MY GARAGE AT NORTHCREST
Project No. 25020 April 16, 2026
Sheet 1 of 3

V1_PLAT DRAWING.PDF MARKUP SUMMARY CLIENT/LDC COMMENT RESPONSES

EXHIBIT "B"
PRIVATE DRAINAGE EASEMENT

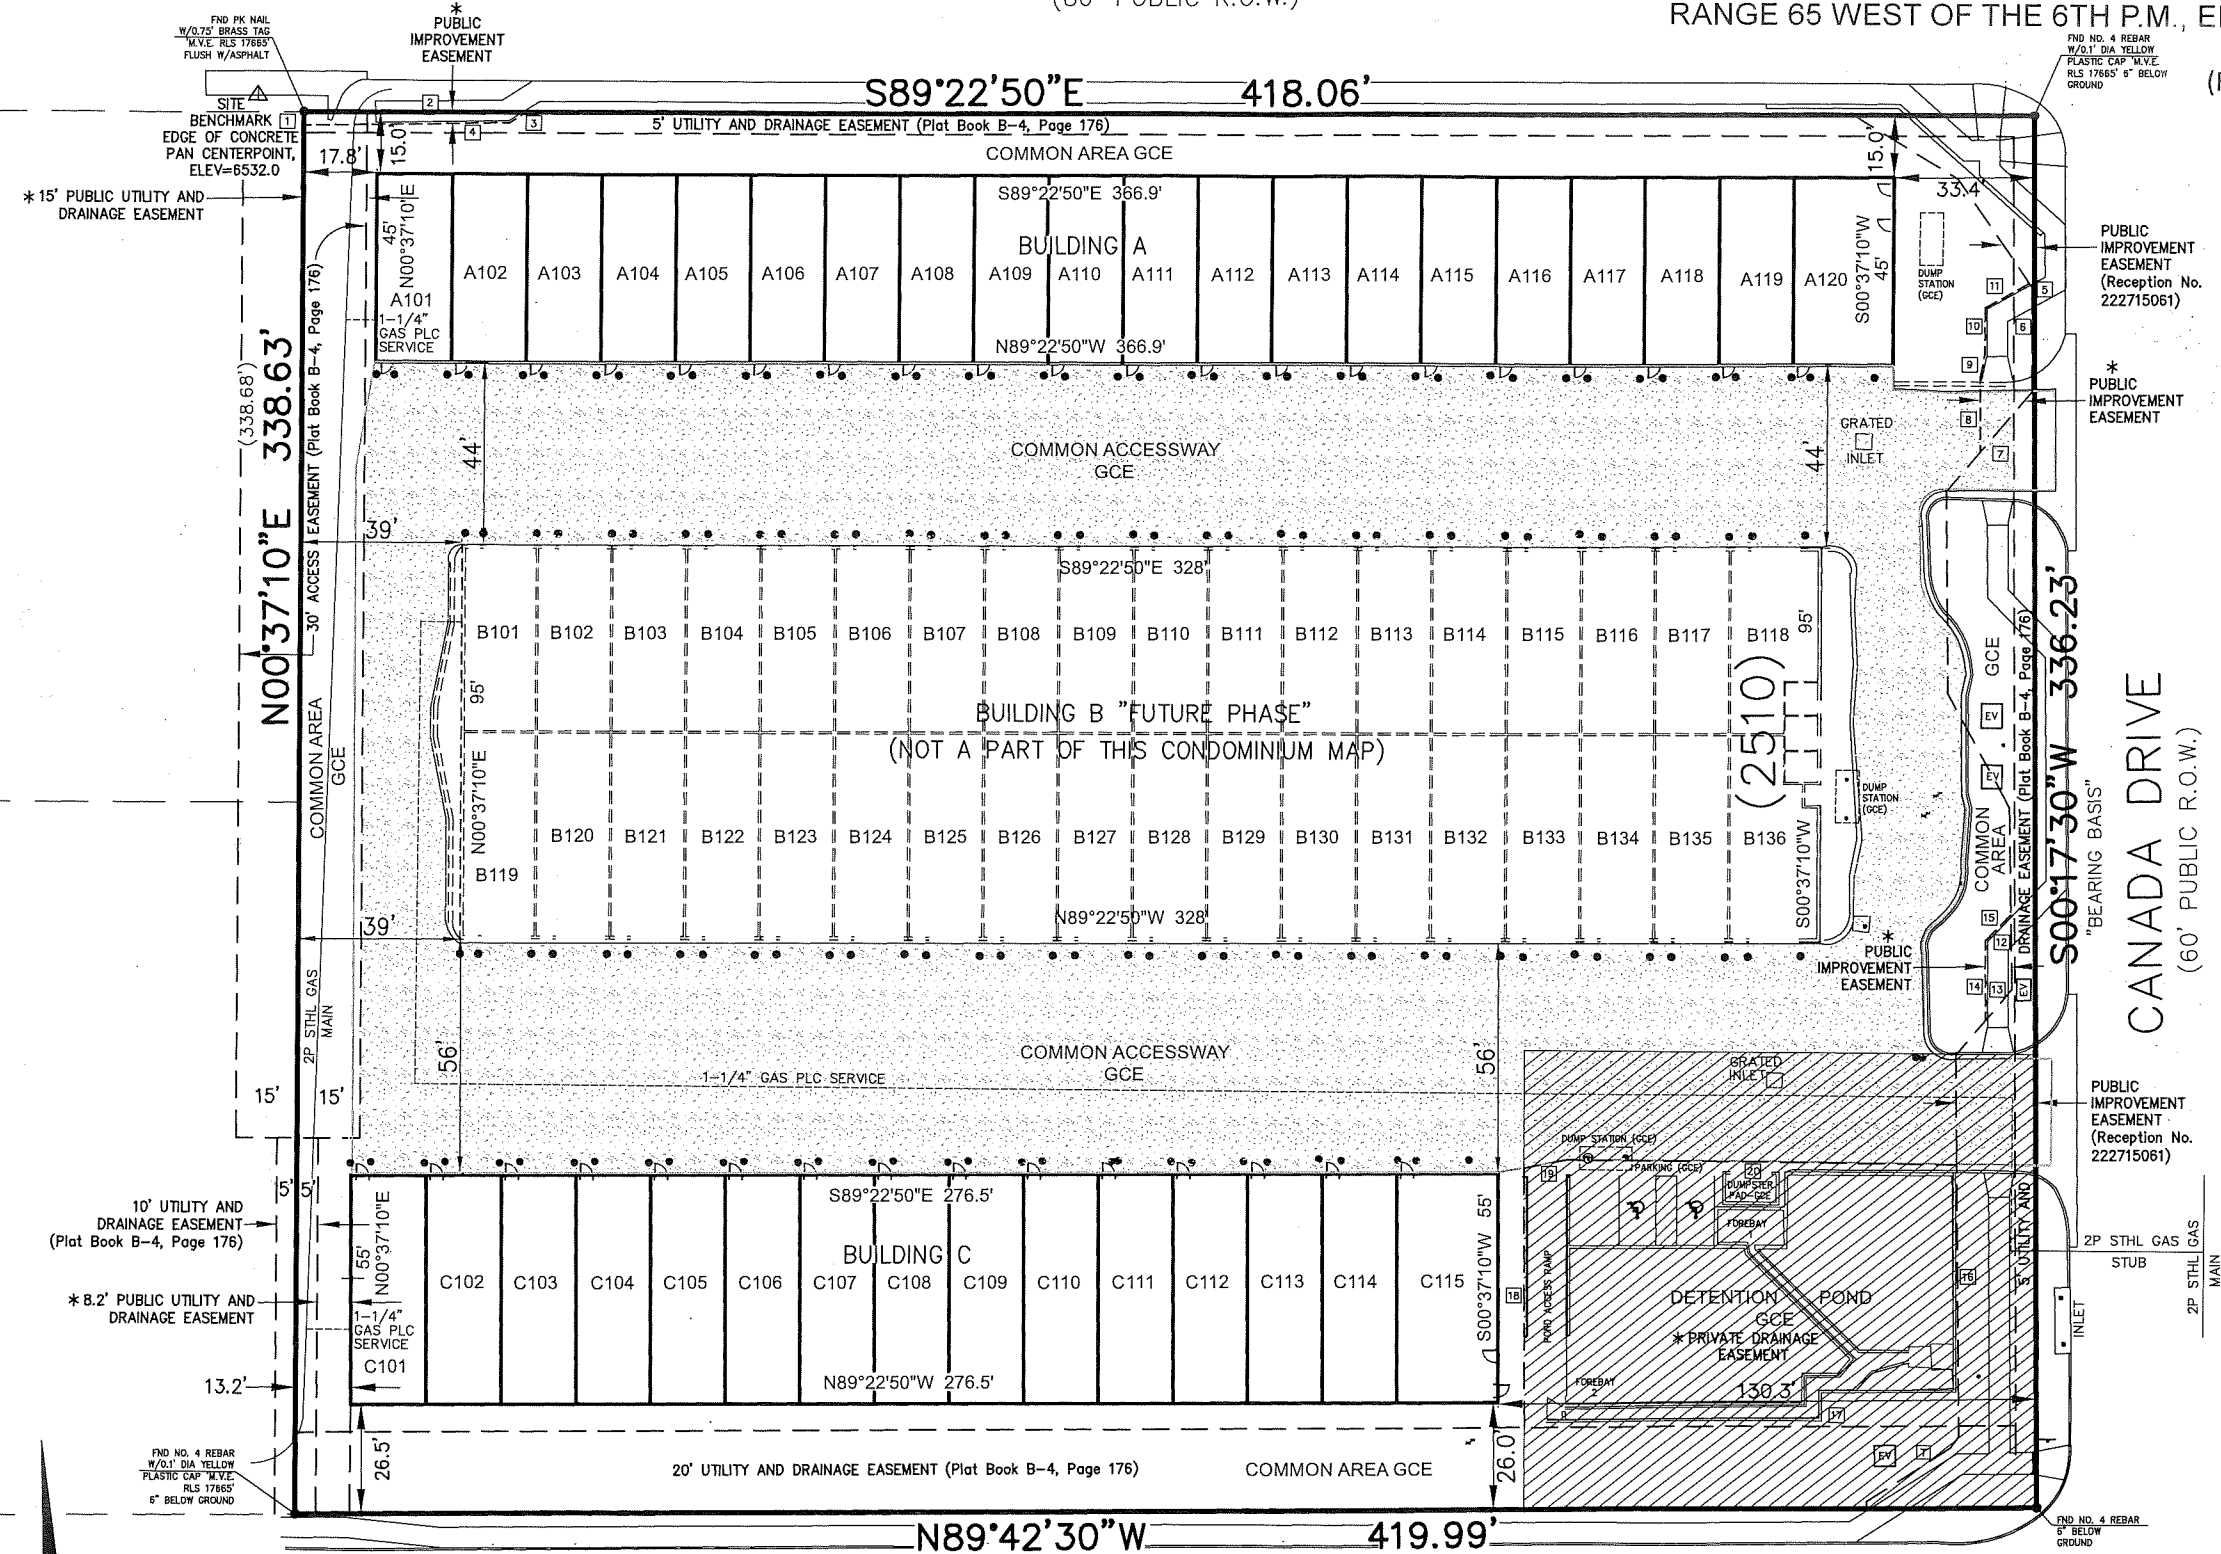
36. Noted within units and per note on Sheet 3 of 3, with applicable bearings noted on Sheet 1 of 3.
37. Depicted, delineated and labeled with created Private Drainage Easement on Sheet 1 of 3.
